NORTH FALLS OFFSHORE WIND FARM

Appendix G4.2 to the Natural England Deadline 4 Submission
Natural England's Guillemot and Razorbill Compensation Advice on the Applicant's
Deadline 1 and 3 Documents

Planning Inspectorate Reference EN010119

25 April 2025

Figure 1a-f Long List of Auk Colonies in Devon and Cornwall Considered in Screening:

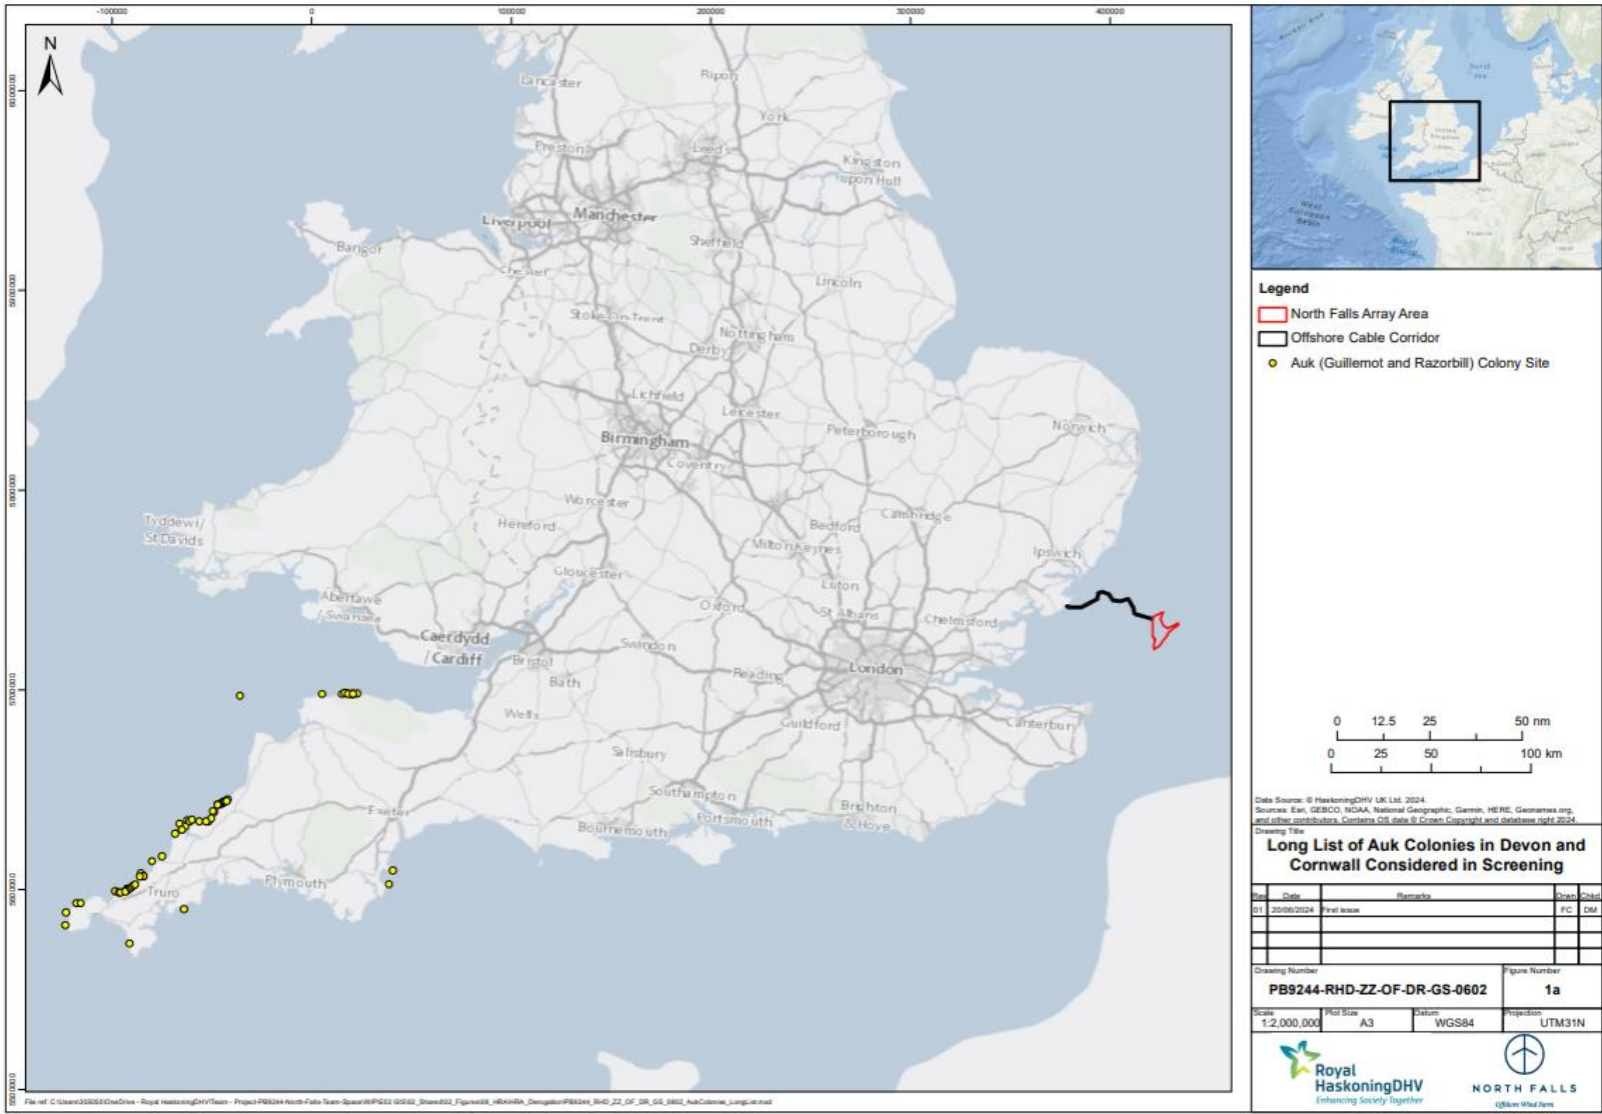
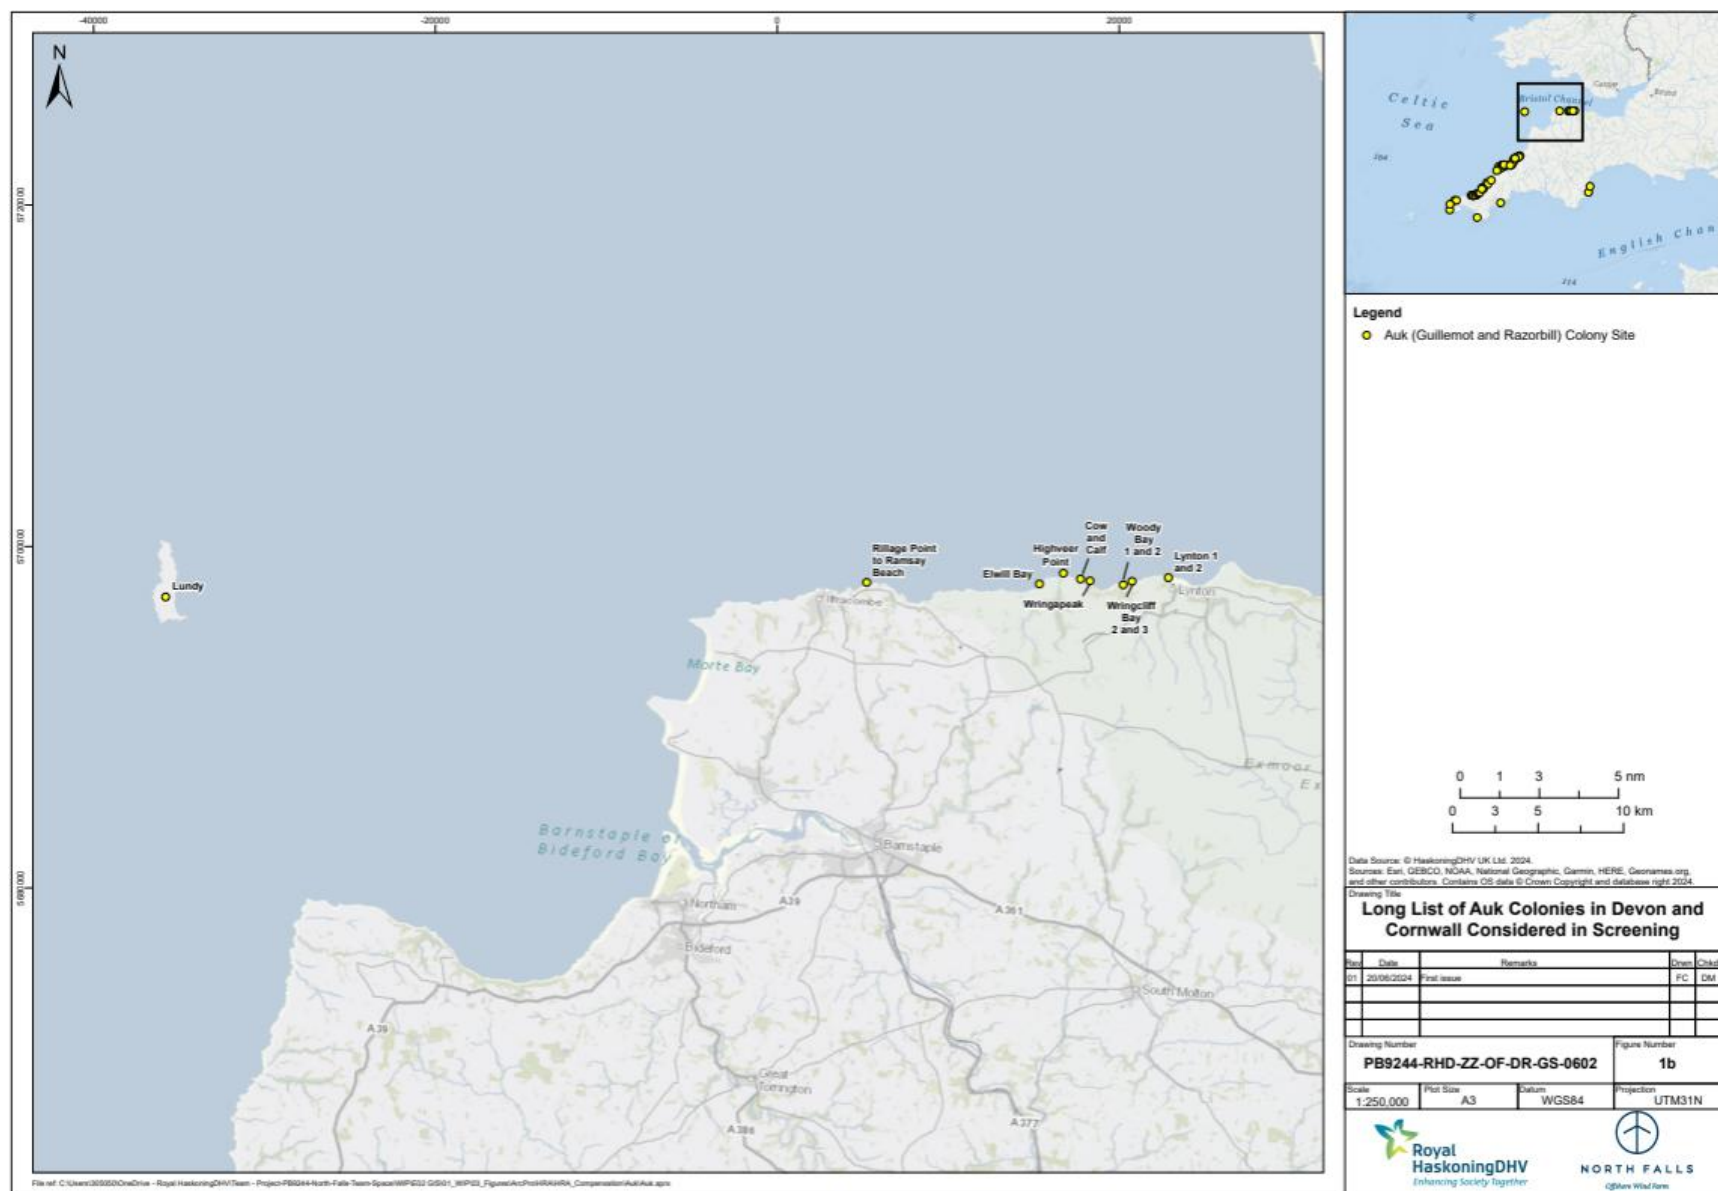
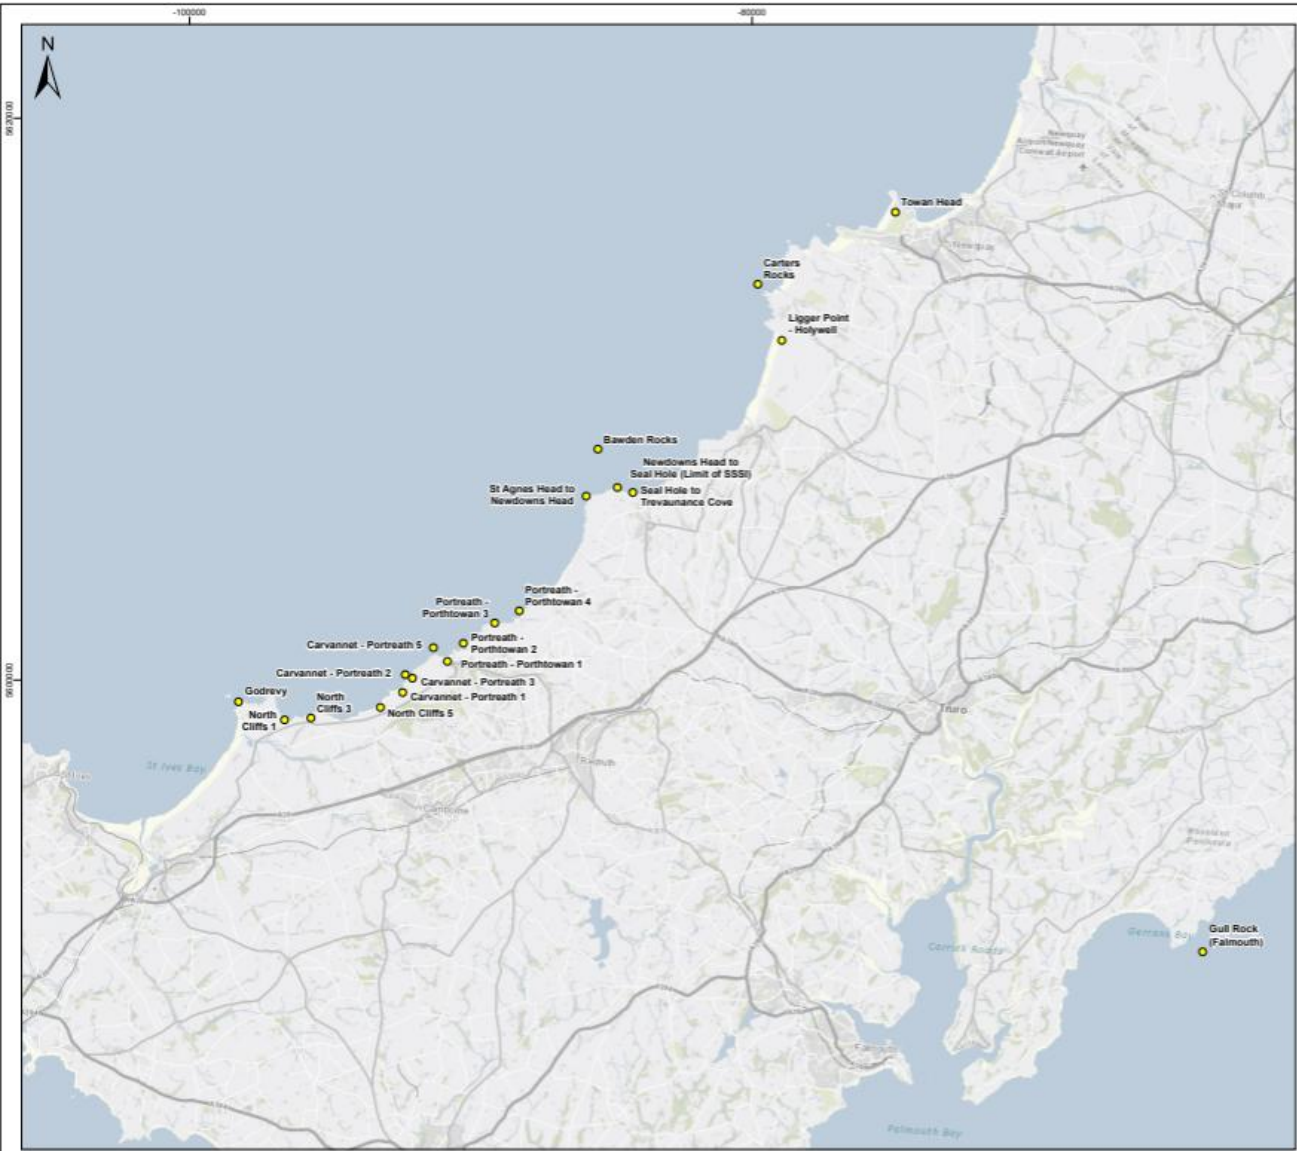
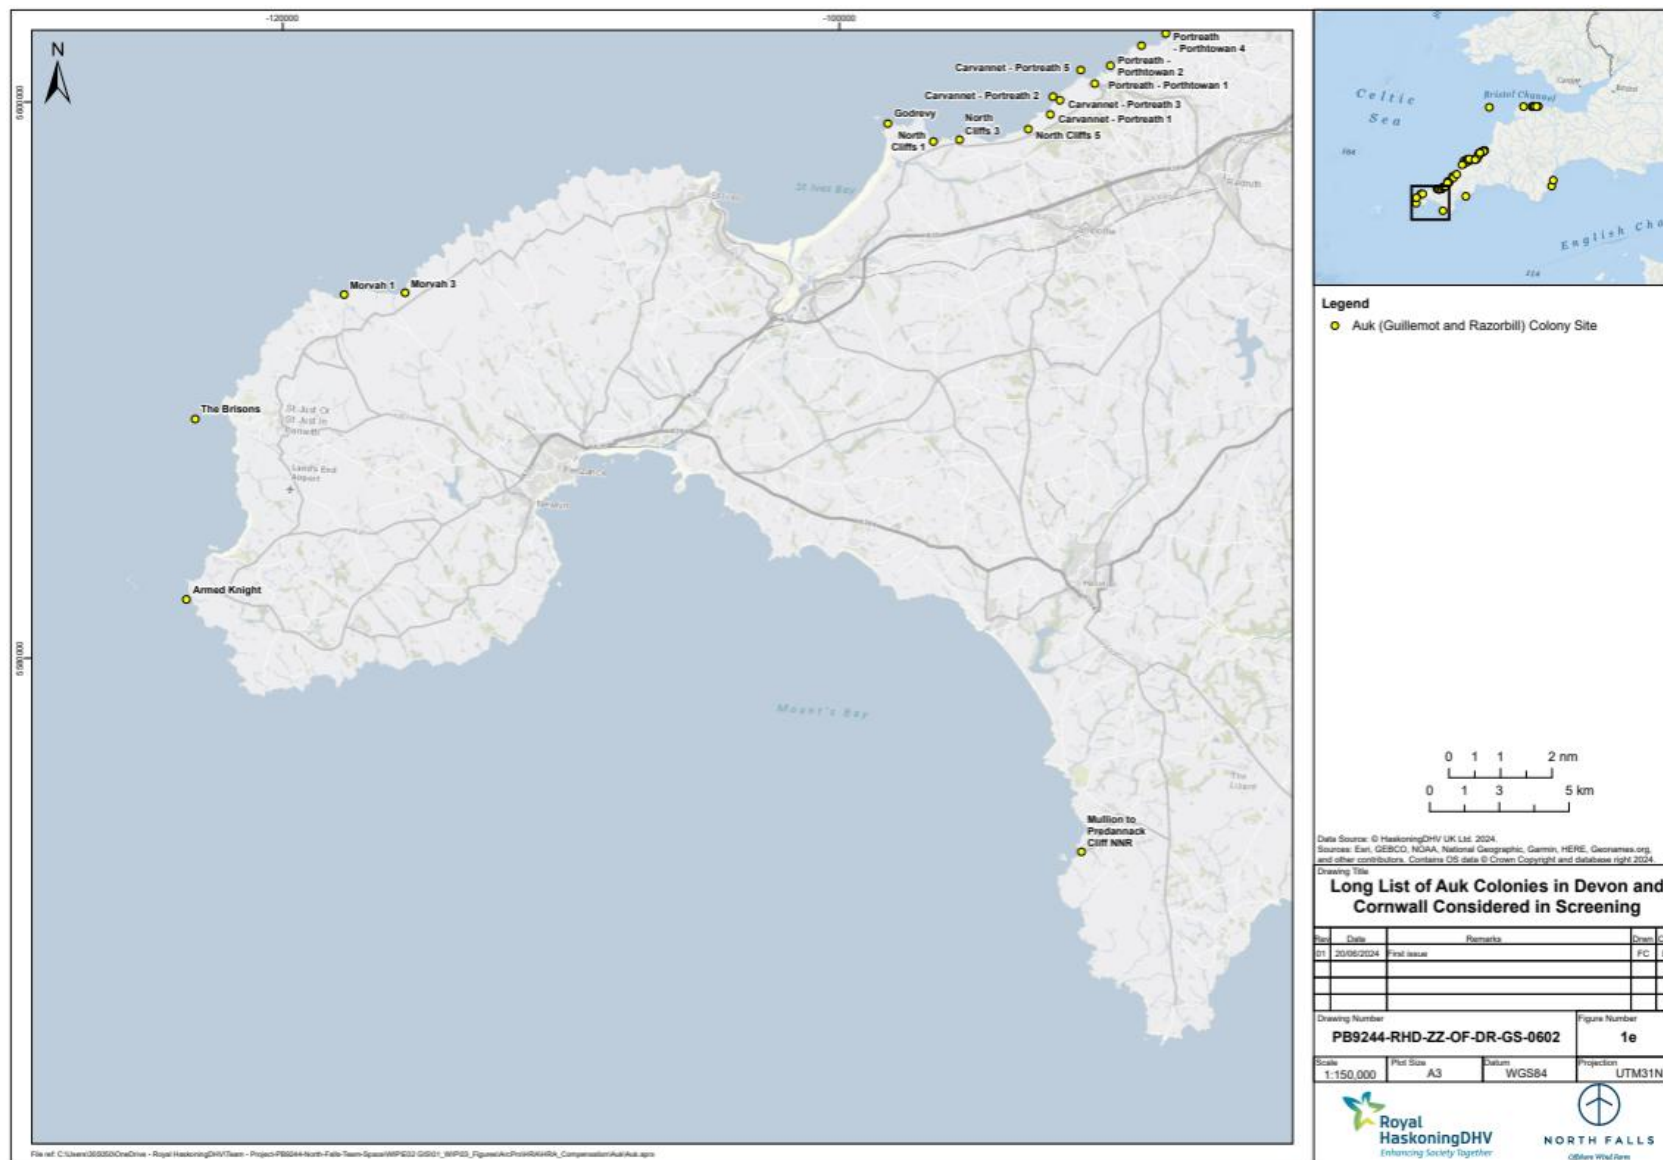
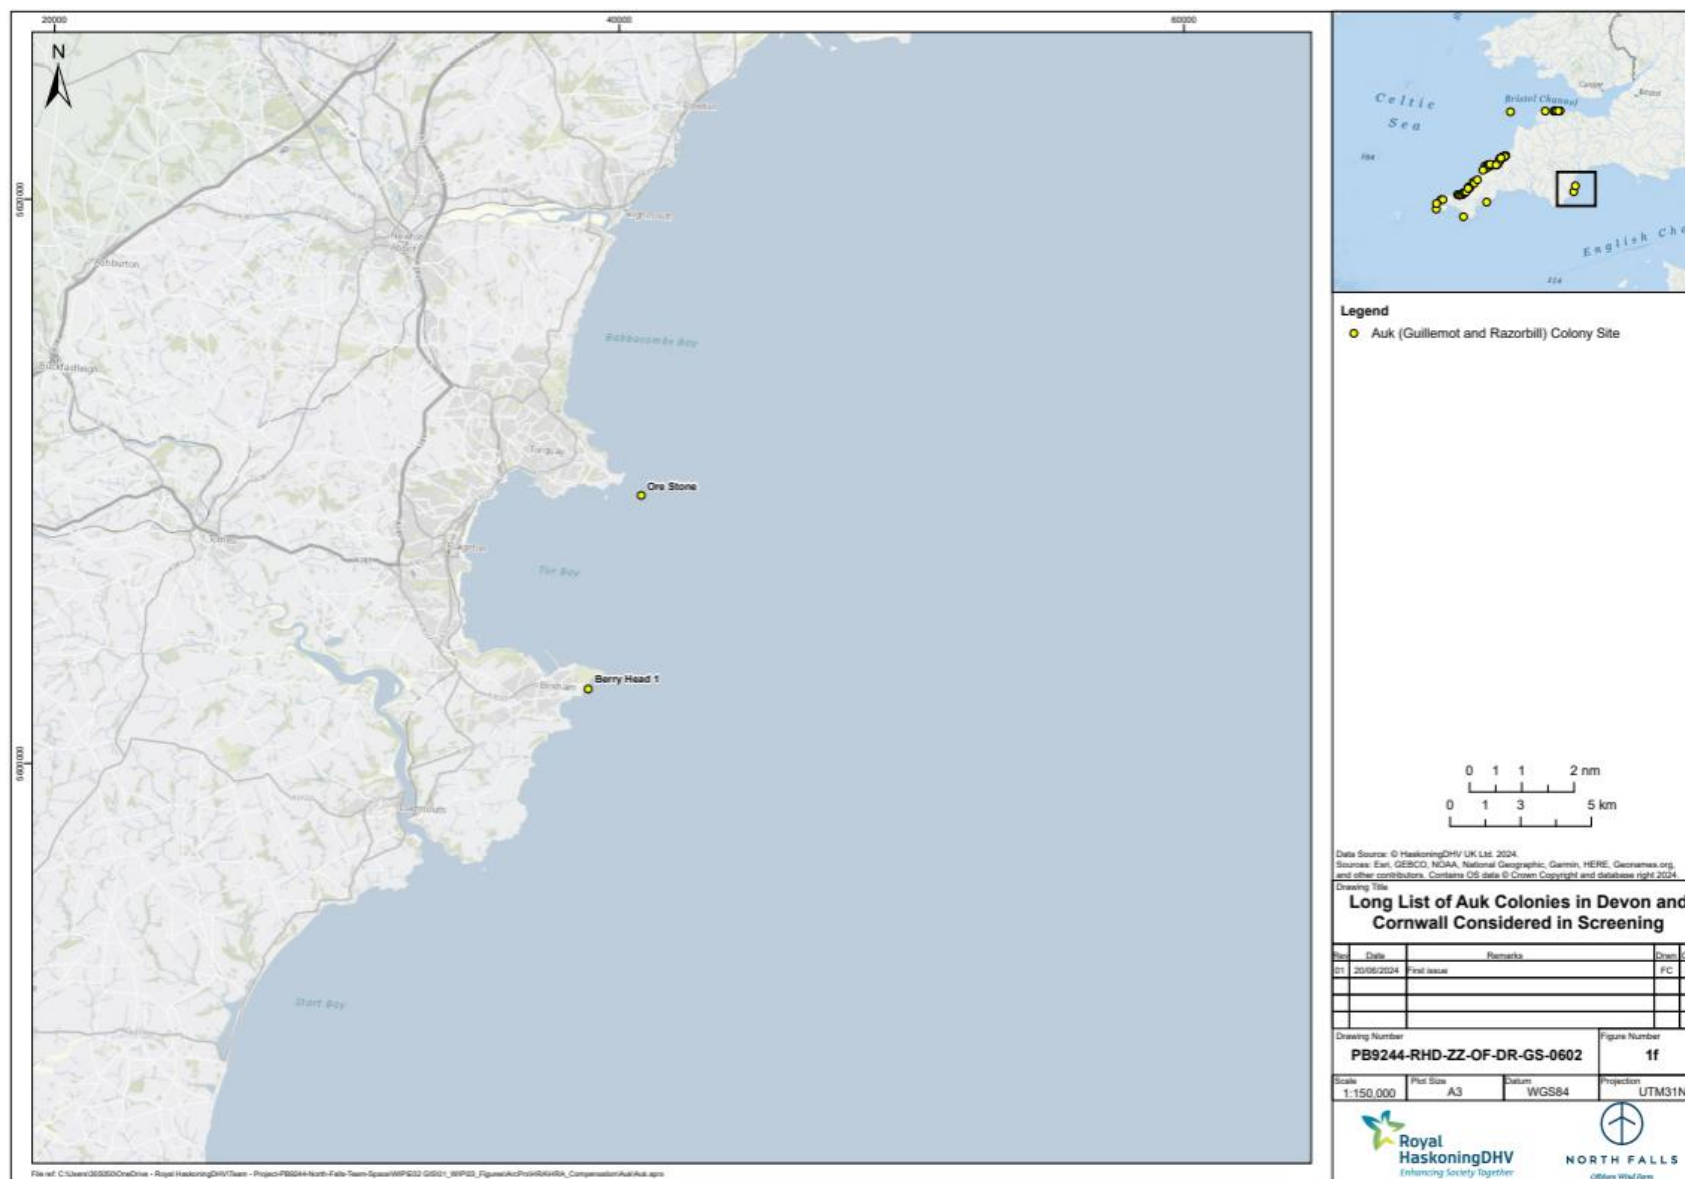
<p><u>Colony Counts</u></p> <p>Natural England highlight that many of the sites in Devon and Cornwall may not have 'recent' colony counts, and their status may be unknown. While many of the sites in Table 5.6 do benefit from recent counts, North Cornwall 2 has not been counted since 2017. Natural England highlight that the short listing of sites is likely to have been biased toward those sites with recent count data. This is understandable but does risk the early elimination of data poor sites where interventions could be successful.</p> <p><u>Correction Factors</u></p> <p>Natural England suggest caution in applying a correction factor to calculate a potential increase in breeding pairs. Walsh et al (1995) state the recommended census unit for guillemots is the individual on land and advise against the routine use of a correction factor due to problems of interpretation and some evidence that at some colonies the relationship between the number of breeding pairs and the number of adults is different (e.g. del Nevo, 1990). Indeed, Harris (1989) makes a plea for the presentation of original counts rather than 'corrected' figures in published work. Furthermore, Harris et al (2015) subsequently point out that the correction factor to convert individuals into breeding pairs changed substantially over the course of their long-term study due to decreases in survival and colony attendance, a situation that may well be replicated in the declining southwest colonies under discussion.</p>	<p>No details have been provided for either the historic or recent counts presented in Table 5.6 in terms of count methodology when calculating indicative compensation potential. Thus, it is difficult to assess how indicative they are likely to be. We also advise that counts should be undertaken prior to implementation of the compensation measure (replicating methodologies of historic peak counts if possible) to establish a baseline.</p> <p>More generally, Natural England advises that the sporadic nature of historic and recent monitoring of mainland auk colonies in the south-west introduces significant uncertainty as regards population trends. Further, there is limited information regarding pressures on these colonies, despite the recent, welcome efforts of developers to gather initial data. In that light, it is important for the proposed collaborative approach to integrate an appropriate level of ongoing monitoring of both the candidate colonies and the pressures on them.</p> <p><u>Correction Factors</u></p> <p>The correct reference for the potential use of the correction factor is Walsh et al., (1995) based on studies by Birkhead (1978) and Harris (1989). Where more accurate studies of guillemot populations are considered necessary, the most suitable method is counting individuals at truly randomised study plots, not chosen for convenience (Harris et al, 1983). Photographs showing mapped nests in these plots can then be replicated and compared year on year where productivity monitoring is undertaken. Natural England advise that consideration be given to establishing site specific correction factors at colonies/regions where compensatory measures are implemented. In-lieu of</p>
